From: Stephan Vargas-Pritchard [REDACTED]
Sent: 25 October 2023 17:26
To: Jessica Riches
Cc: Jon Gateley
Subject: RE: P/153/21/RES - Summer Lane
Attachments: October Resubmission Approval Sheet.xlsx; 21.129.92A_House Type Fv_CA2b - Plans and Elevations.pdf; 21.129.97A_HT Iv_CA1 - Plans and Elevations.pdf; 21.129.48C_Blkc_CA1 - Plans and Elevations.pdf; 21.129.49C_Blkc E1_CA4b KB - Plans and Elevations.pdf; 21.129.50C_Blkc E2_KB - Plans and Elevations.pdf; 21.129.51C_Blkc F1_CA4b KB - Plans and Elevations.pdf

Subject: P/153/21/RES - Summer Lane

Rev.	Description	DATE	DB / CB
Date		Oct '21	
Drawn By/Checked By		VP/HJE	
Scale		1:2500 @ A2	
Revision		-	
Project	Land South of Summer Lane Pagham		
Title	Location Plan		
Dwg#	21.003.01		
Status	Planning

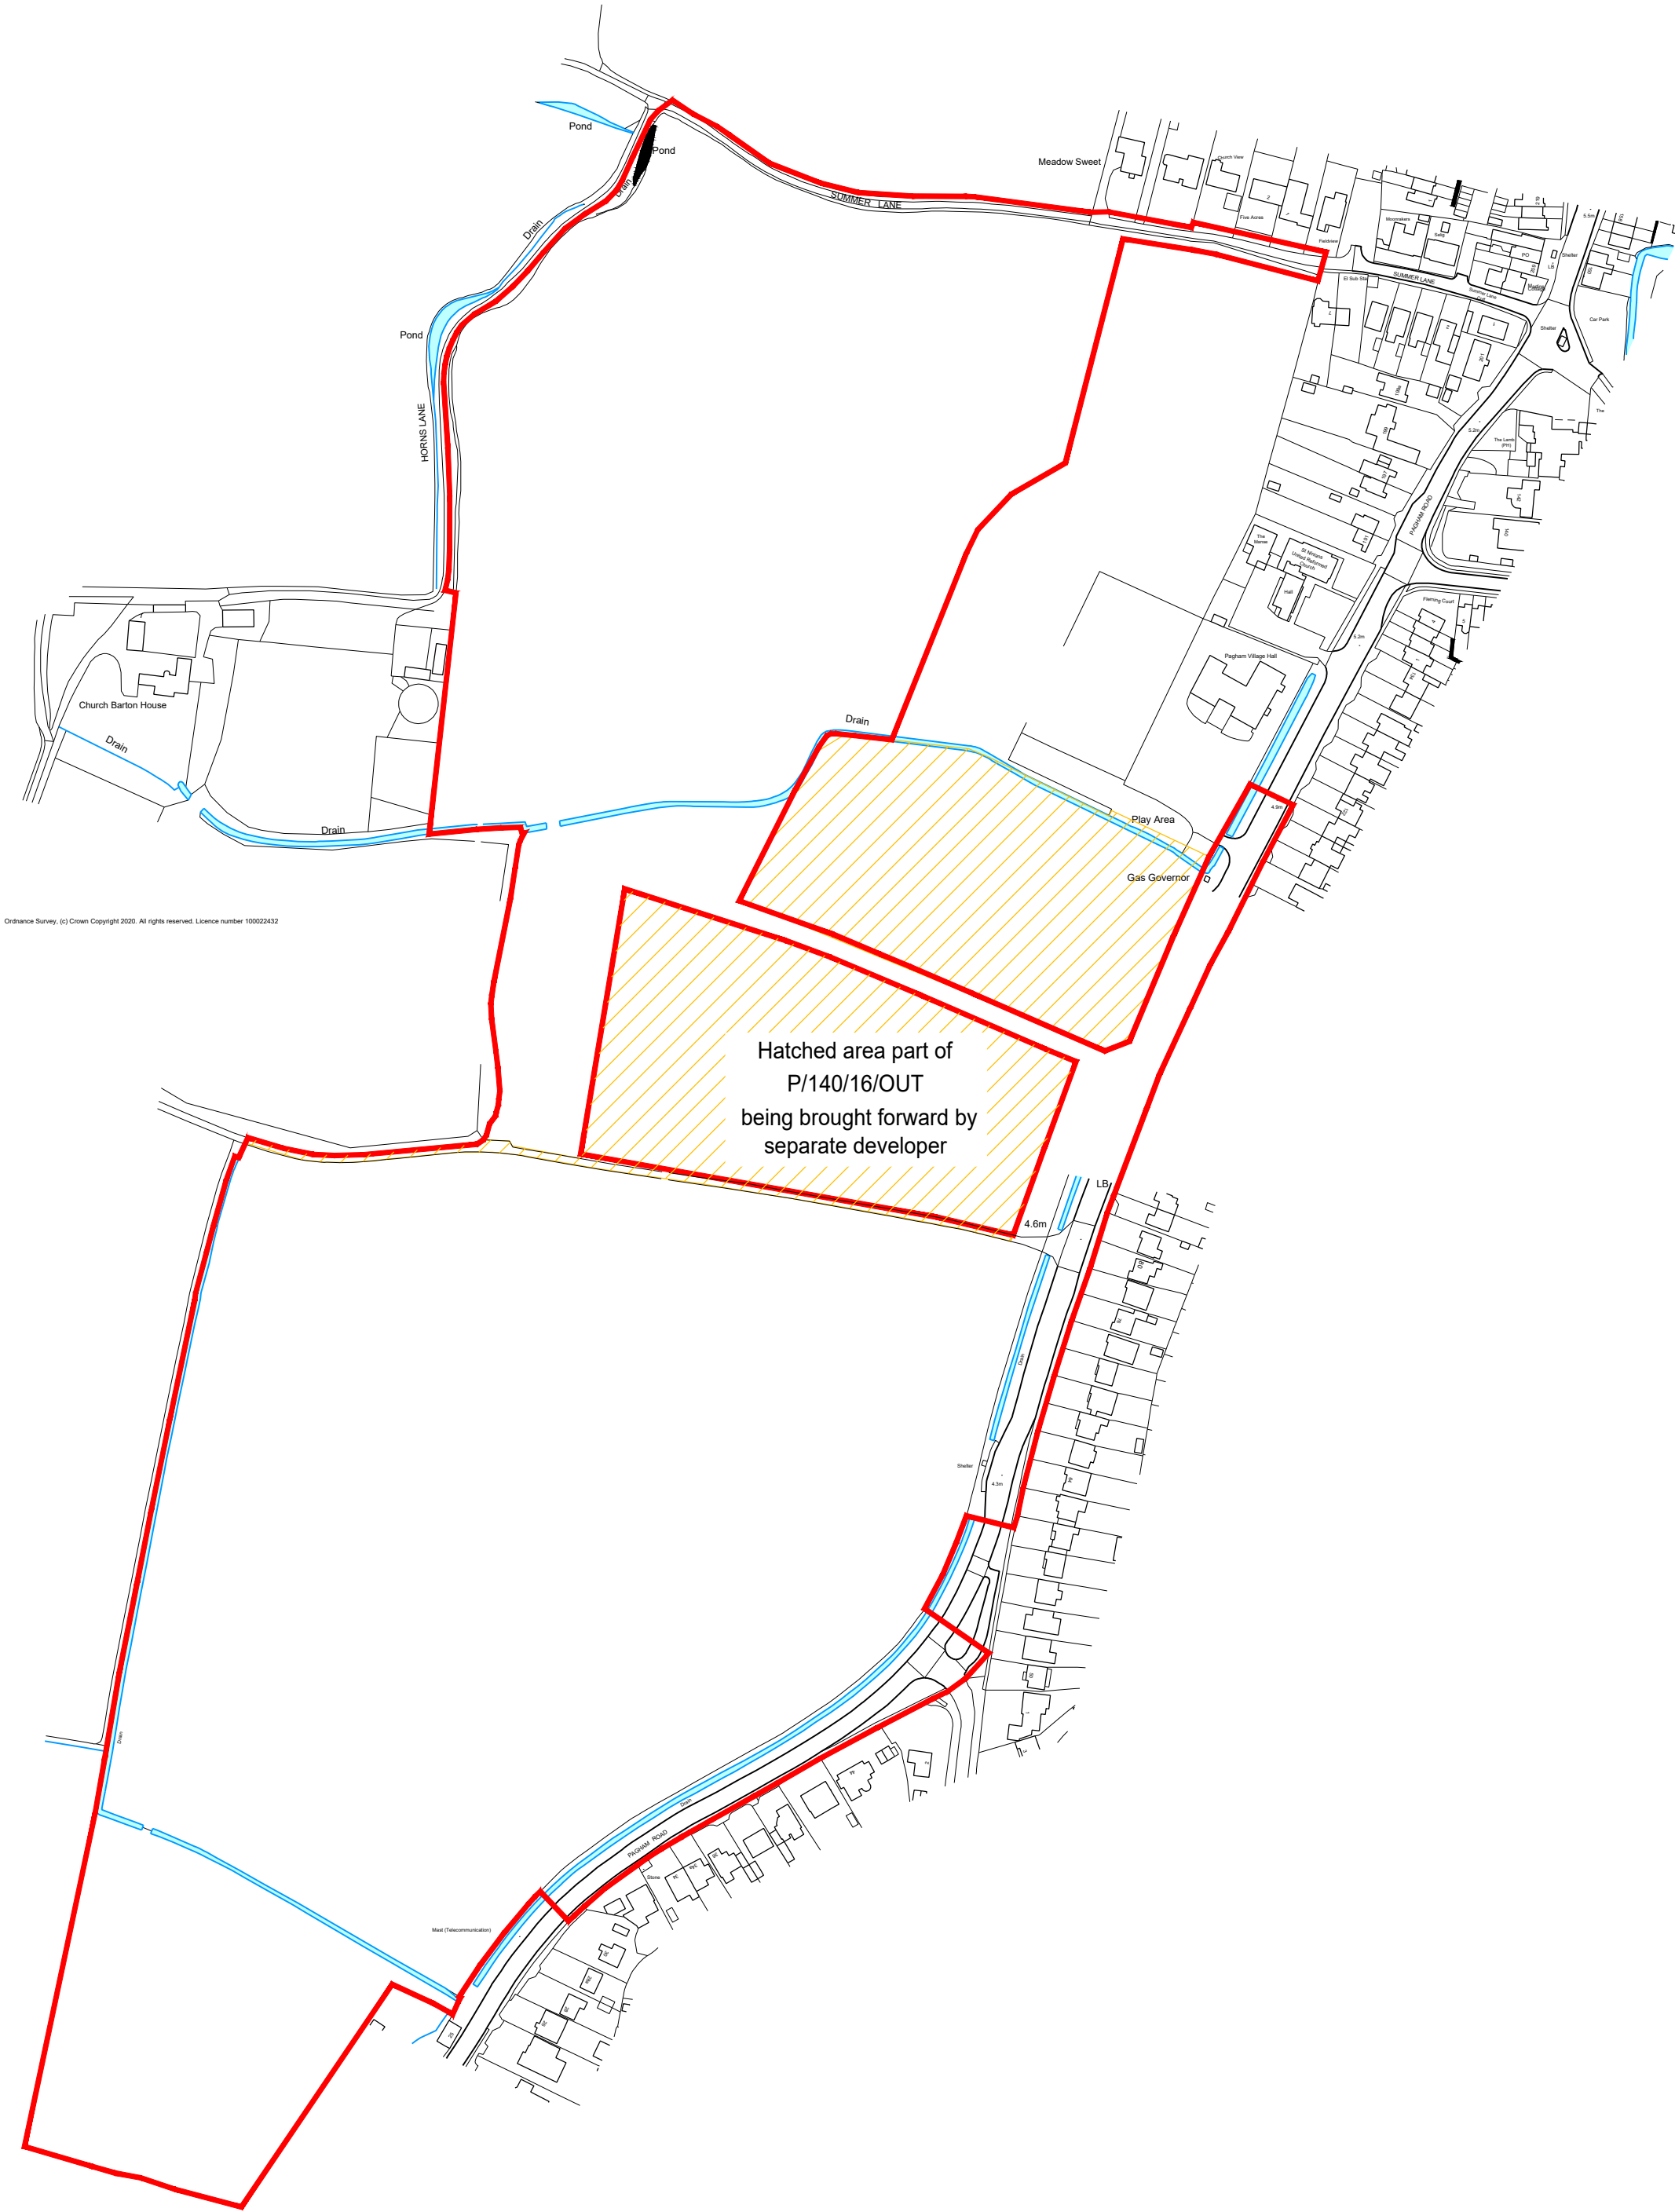
- Location Plan has a completely different reference number sheet says 21.192.01 but it is 21.003.01
- 21.003.48 Block C(CA1) we had a revision A so have superseded it but do not appear to have a Rev C
- 21.129.49 Block E1(CA4b KB) sheet sys rev A but we already have a rev B
- 21.129.50 BlockE2(KB) we had a revision B so have superseded it but do not appear to have rev C
- 21.129.51 BlockF (CA4b(KB) sheet says Rev B but we already have a rev C
- 21.129.86 Landscape framework plan - do not appear to have this.
- 21.129.92 Block Fv(CA2b) the new plan rev A was not supplied - it was a repeat of the one without a revision no.
- 21.129.97 HTIv(CA1 KB The new plan Rev A not provided

Regarding the Location Plan – the reference for this application (P/153/21/RES) is 21.192.01 whereas it appears you are referring to the Location Plan for the mirror application.

document number
10095-FPCR-XX-XX-DR-L-0023

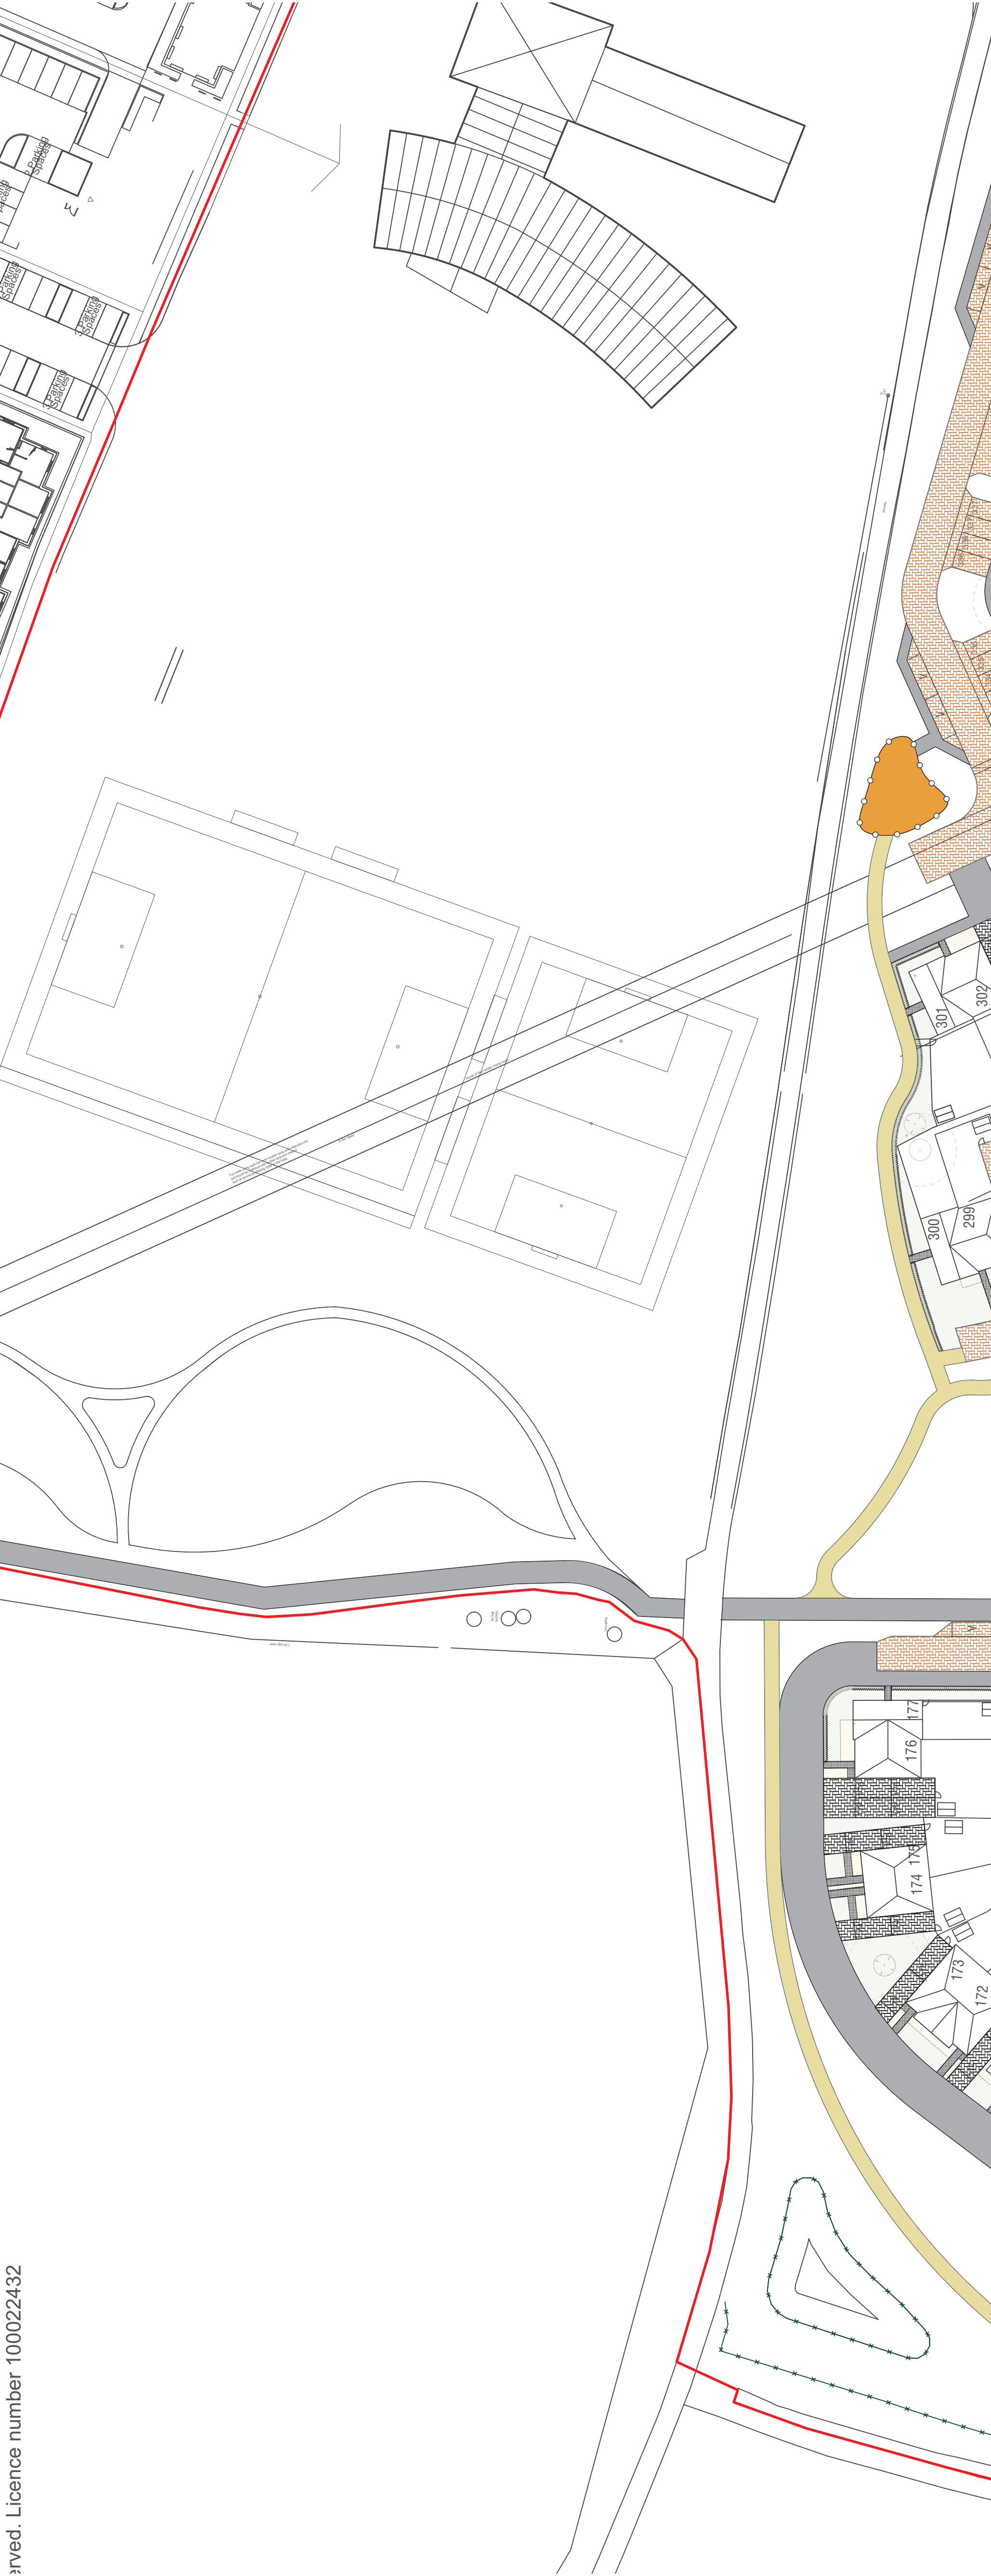
In addition, I have been reviewing the Hard Landscape Plans 10095-FPCR-XX-XX-DR-L-0021-0024 P04 from FPCR and can see that the fencing has not been proposed for the entirety of the western boundary and is only referenced on the key to applying to attenuation ponds. Adequate fencing will be a part of the assessment for the AA process, which assesses whether dogs can access the Pagham Harbour land. The site should therefore have continuous and secure fencing along the western boundary, and specifically where are you encouraging off lead activities in the southern section. Fencing should join up with Church Barton where possible to restrict dog activity off lead into the Harbour. Under the current plan, I am unconvinced that we would be able to draw the conclusions of no adverse impacts based upon the absence of a western boundary fence.

Additionally, we would need to see details of said fencing along the western boundary, however your response says, "The Hard Landscaping plan confirms that the proposal is for FSC-Approved Timber Post and Rail Fence to attenuation ponds (1.5m high) with maintenance gate." Please be aware that ADC cannot be sure that there will be no adverse harm if we have no elevations of the fencing – as we will need to assess any additional meshing/stock proofing treatments to assess whether the fence is a suitable physical barrier to stop dogs easily accessing the Pagham Harbour when off lead.

We are also submitting updated landscaping plans which address your comments. Specifically you will note the continuous hedging and fencing along the western boundary and the specification for the fence.
